File: DOC16/576650
Ref: SSD 7484

Sandstone Precinct Stage 2 DA for Tourist and Visitor Accommodation (SSD 7484)

I refer to your email received 15 November 2016 inviting the Heritage Council of NSW (Heritage Council) to comment and provide recommended conditions of consent on the above proposal.

Roof structure

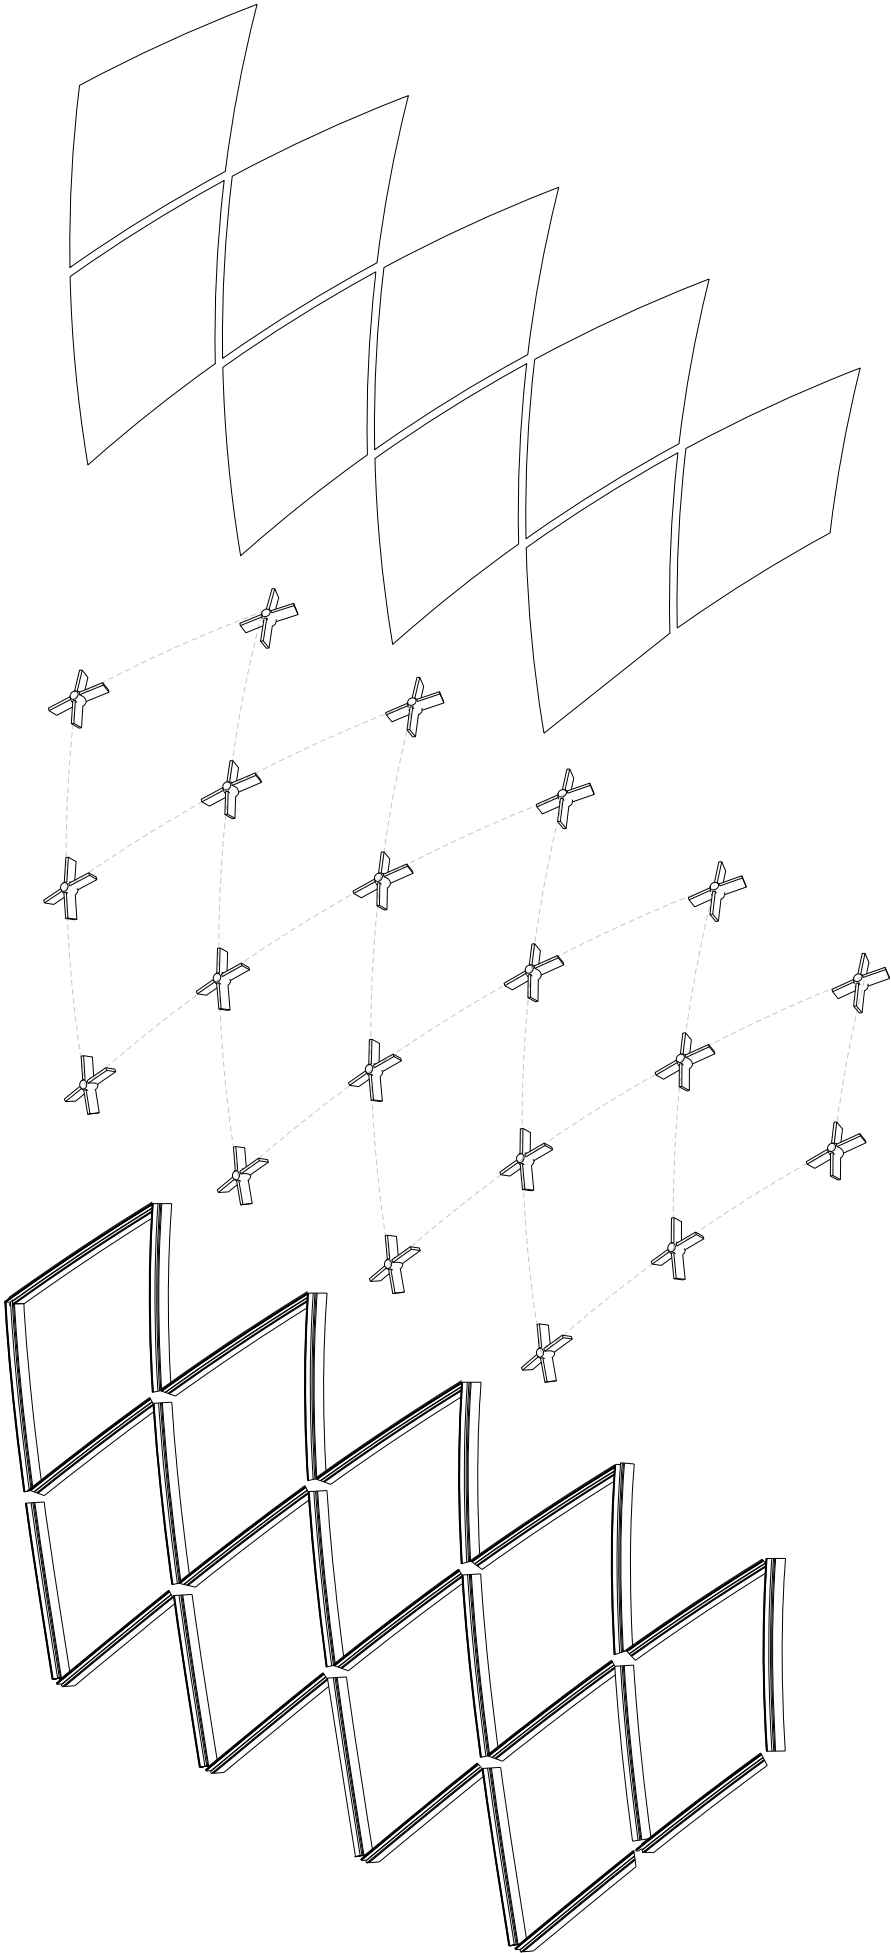
- Details of junctions between the exceptionally significant roof structures and the replacement roof.
 - Elevations showing proposed alterations to exceptionally significant roof structures at the Lands Building. It is recommended that alterations to significant fabric are minimised and that the new roof is designed so that it can be removed without permanent damage to the significant roof structures.

Pool lantern: South elevation
Backgrounds taken from Ridley revit model

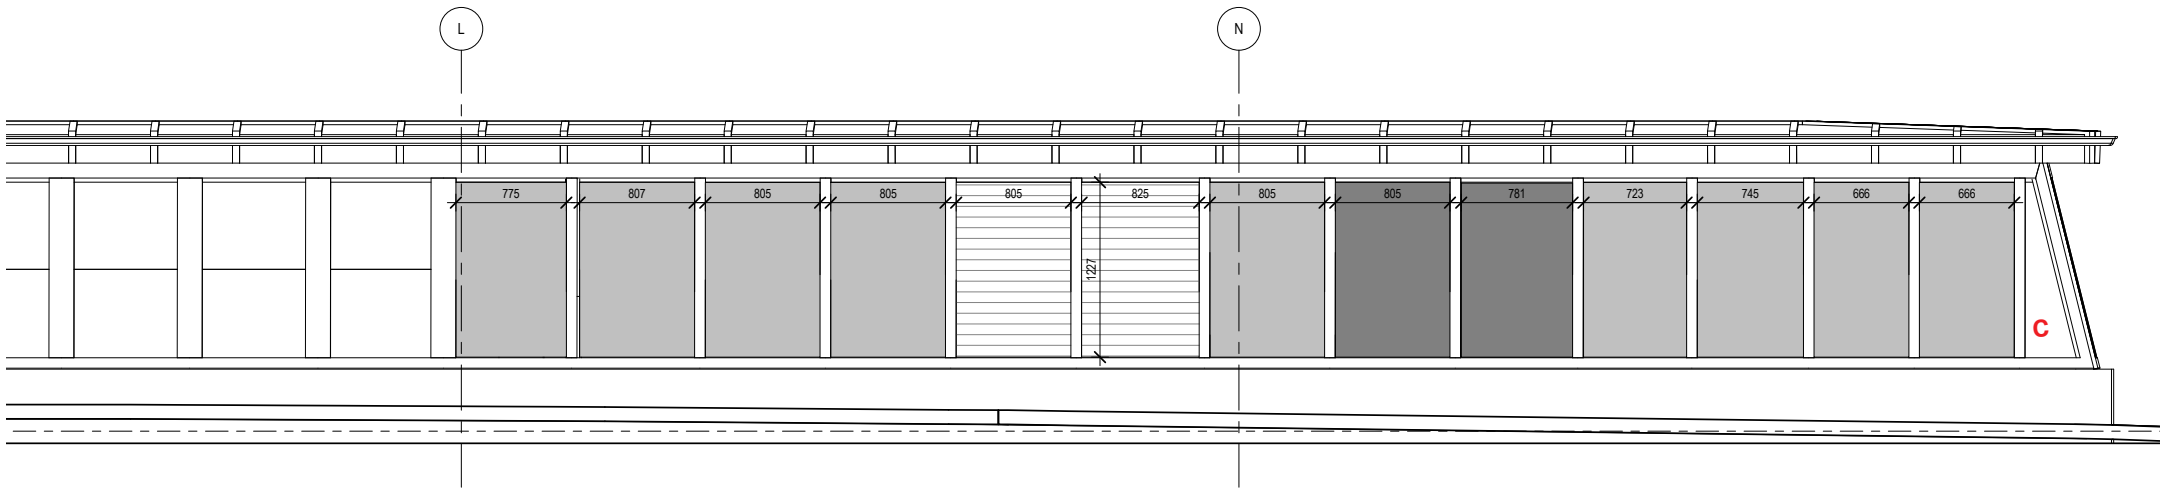
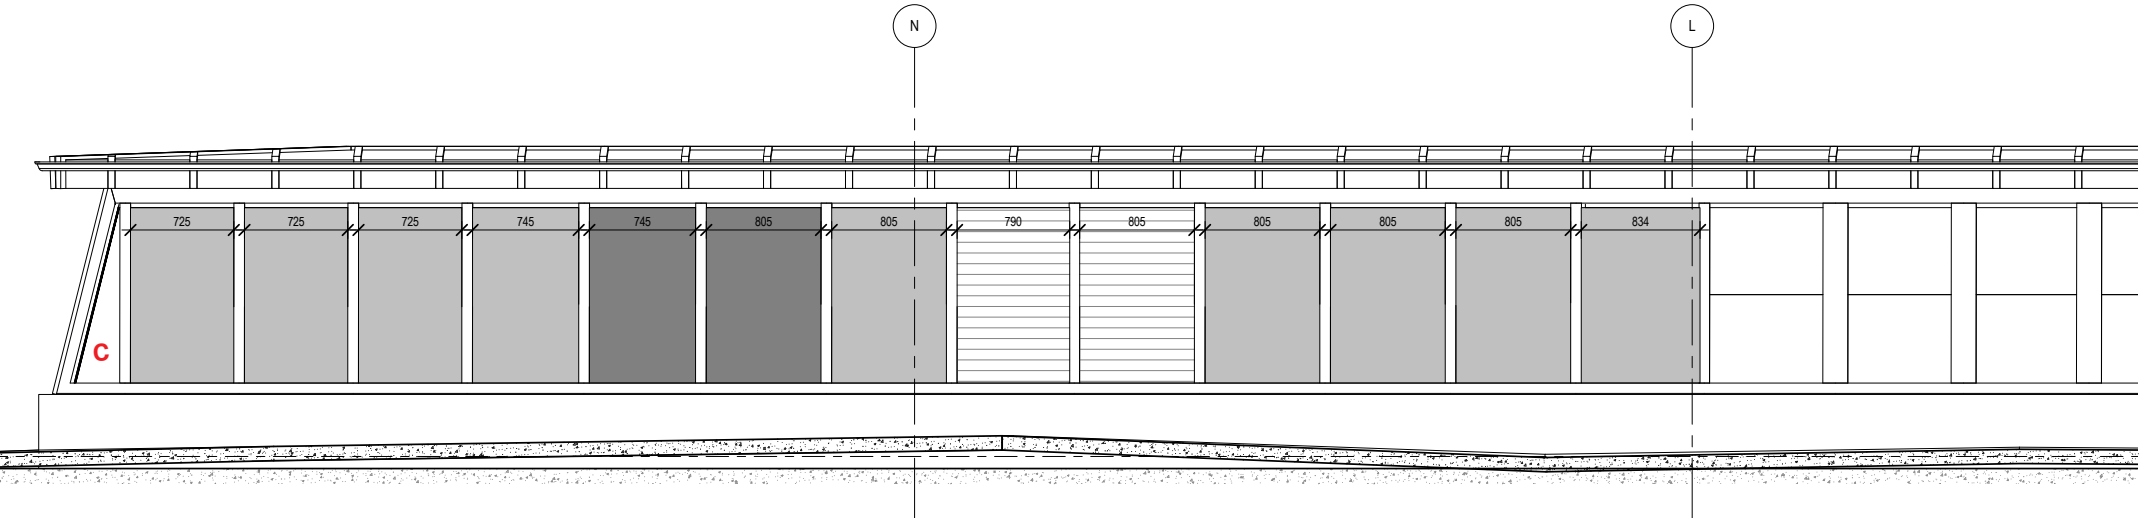
Specifically, the proposed pool and spa and water "villa" at the Education Building are substantial new features that could impact on the heritage fabric and structural integrity of the Education Building. It is recommended that these aspects of the proposal are not supported at this stage and that further detailed information is sought, with input and review from a structural engineer, and that the detailed design is referred to the Heritage Council for comment prior to approval of these works. In the case of the pool and spa, further consideration should be given to interpreting its former use as a ballroom.

- Further details regarding the proposed pool and spa in the Education Building.
 - Further details regarding the rooftop water "villa" on the Education Building.
